Sturton by Stow Parish Council

Q2.1.6 Q2.1.7 & Q2.1.8

Cumulative Impacts Assessments

FIGURE NUMBER
Figure 1-1

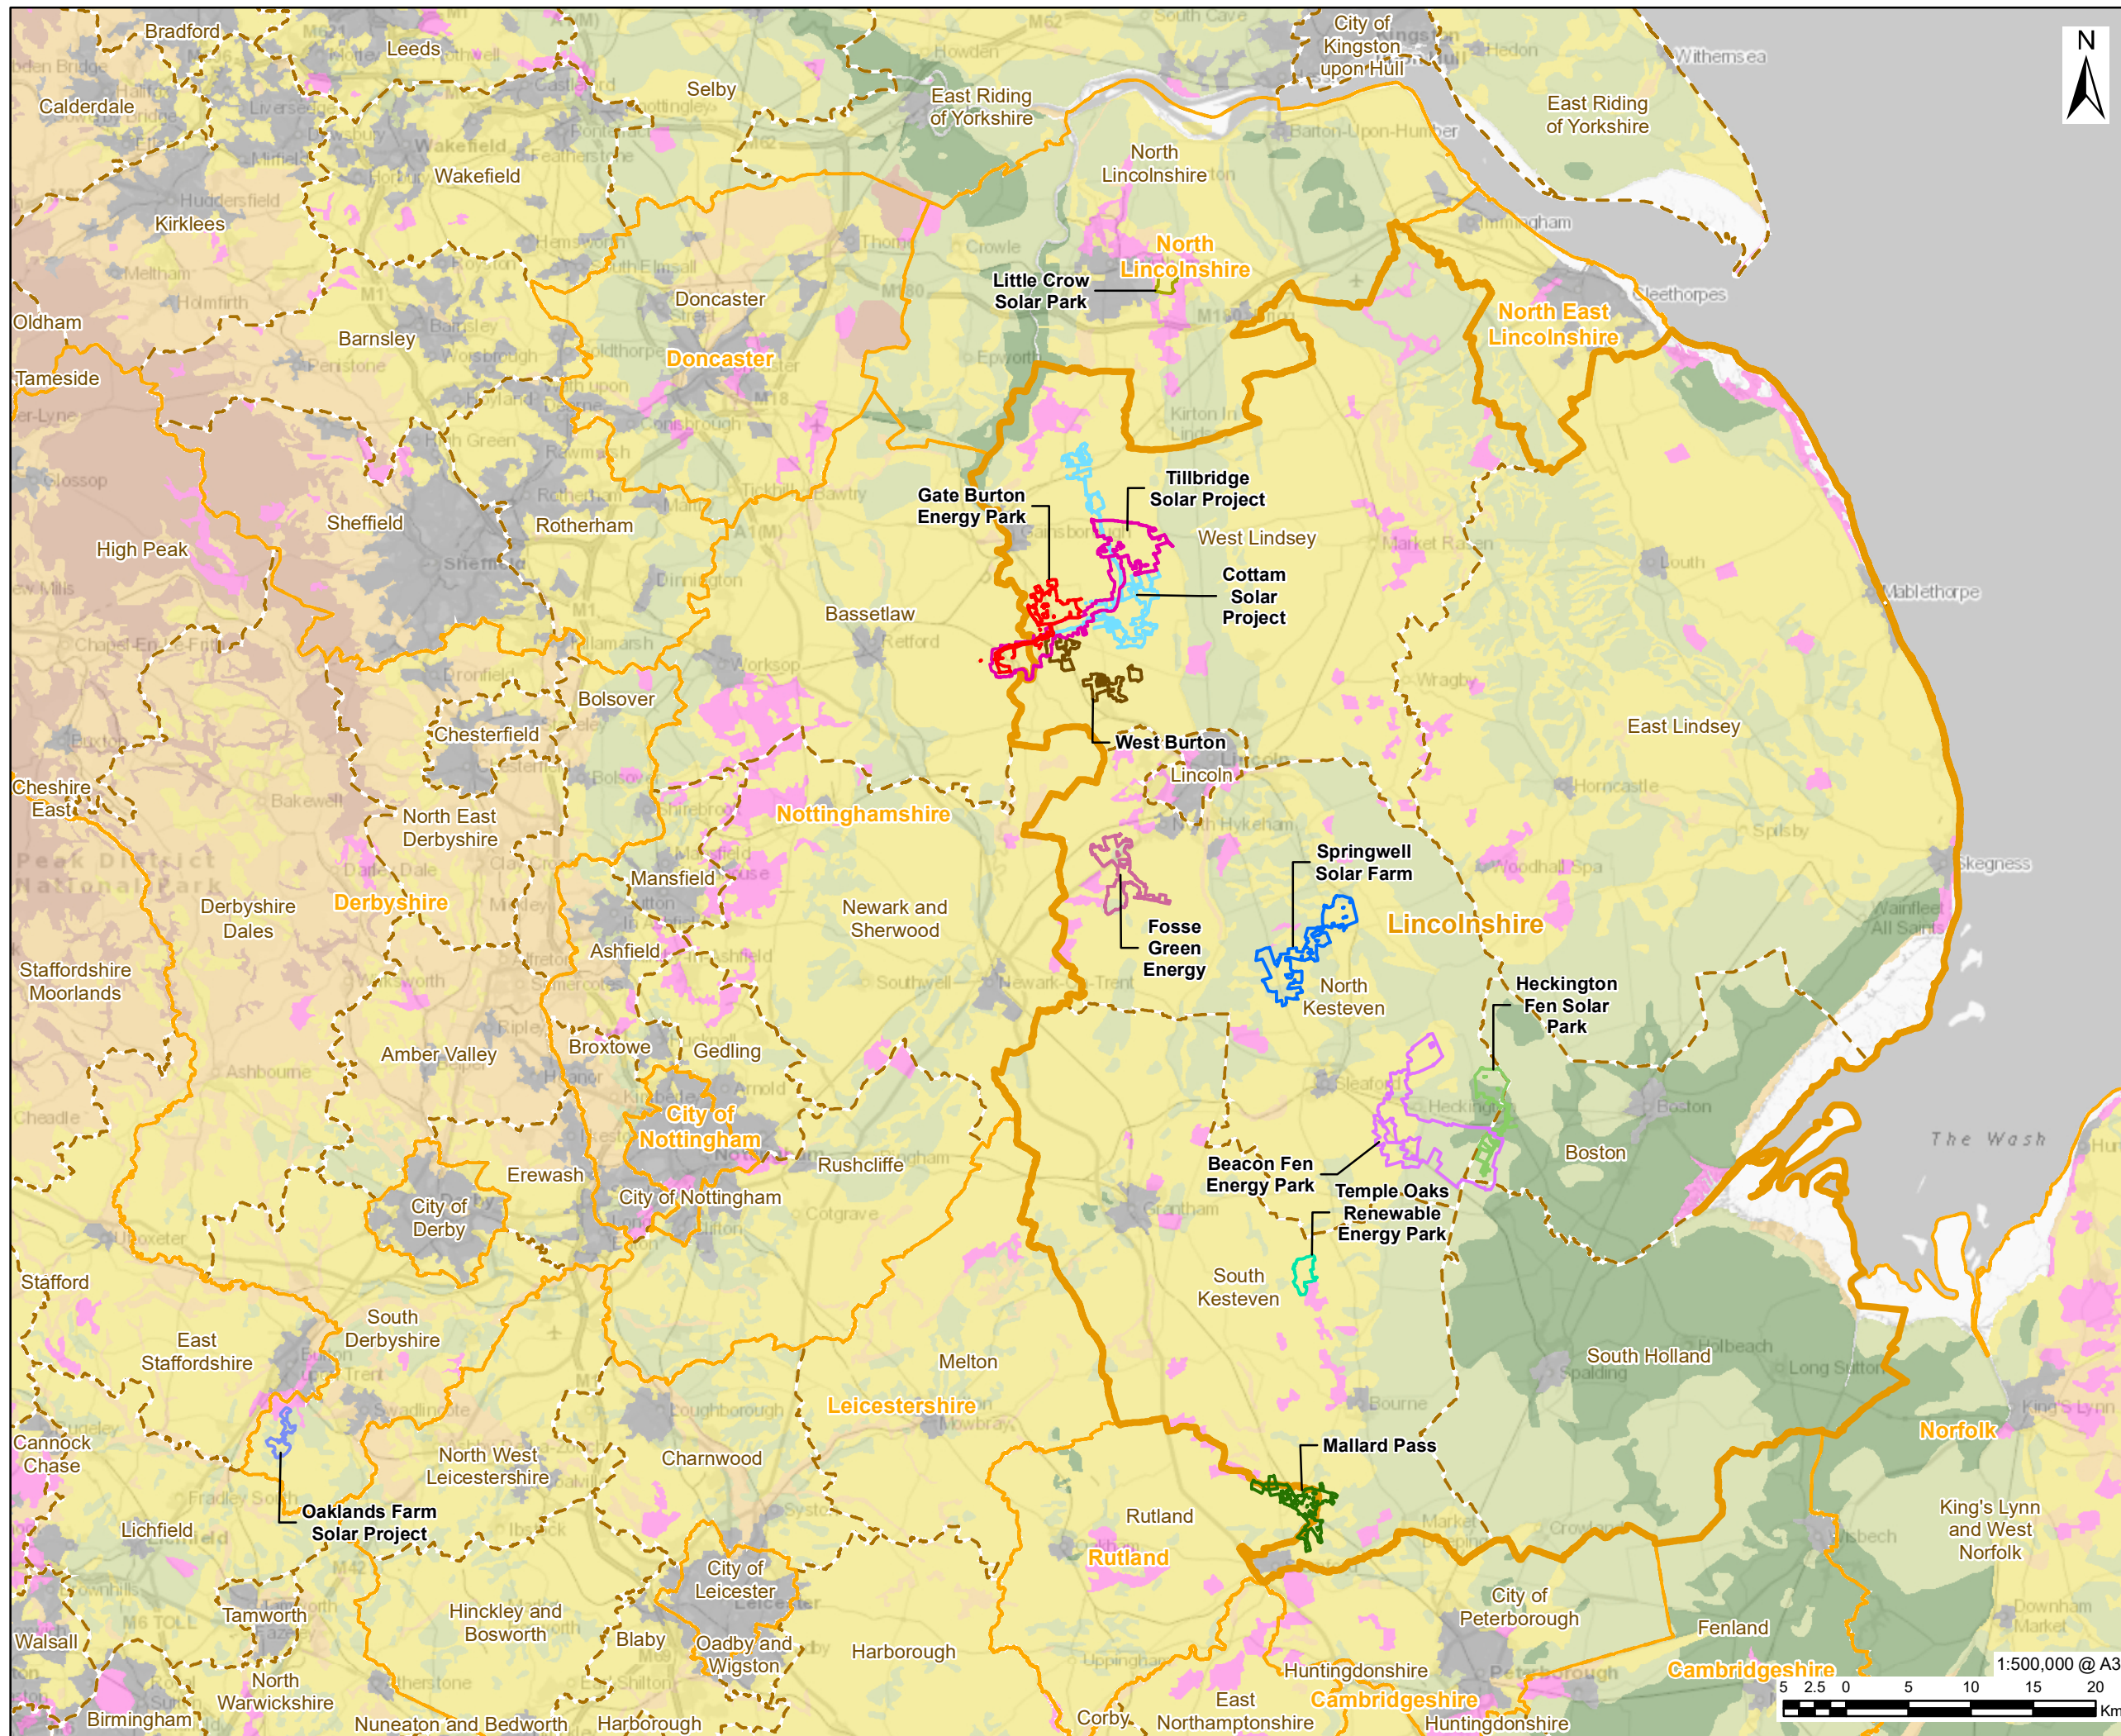
There are at least two more solar sites not listed in documentation and are in the immediate vicinity.

Stow Park (Luminous Energy) sited between Sturton by Stow parish – Westwoods and Marton.

One Earth Project which has just been announced – Sept.2023 - and is projected to be sited south of Dunham Bridge (A57) – each side of River Trent. This applicant is connected with Tillbridge Solar via Sunnica project.

Stow Park (Luminous Energy) and One Earth Solar also to be shown on a cumulative assessment map for clarity.

Figure 1 - Gate Burton Annual Yield

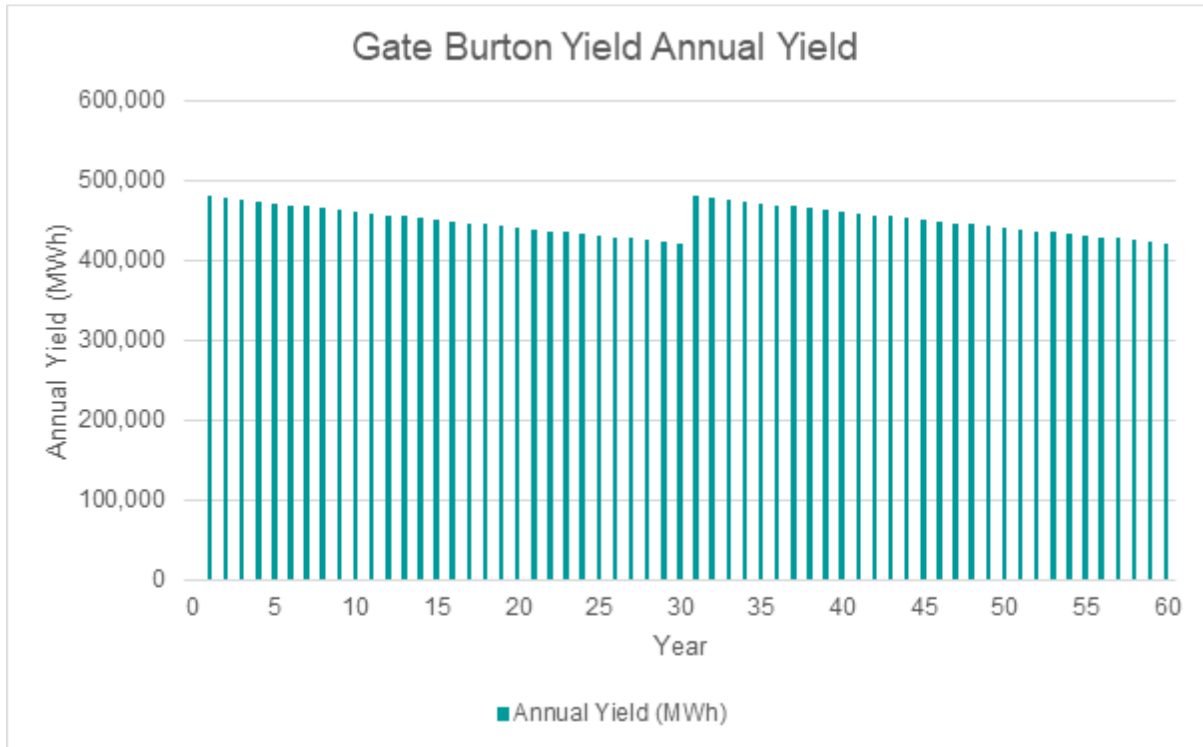
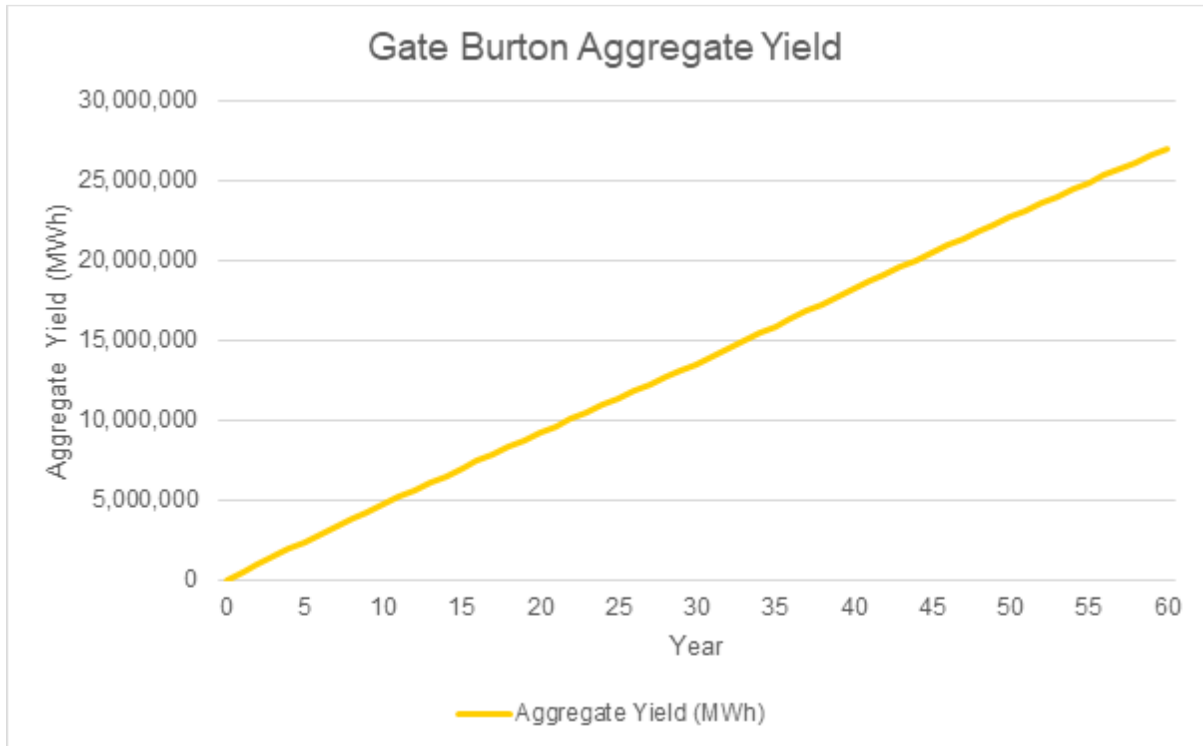
This document sets out the expected degradation of PV panels with replacement on Y30.

There is no reference to ensure additional traffic (or waste removal/recycling) assessment at this time.

There will be multiple events to replace and remove all of the PV panels which will be akin to destruction/construction. This has not been addressed.
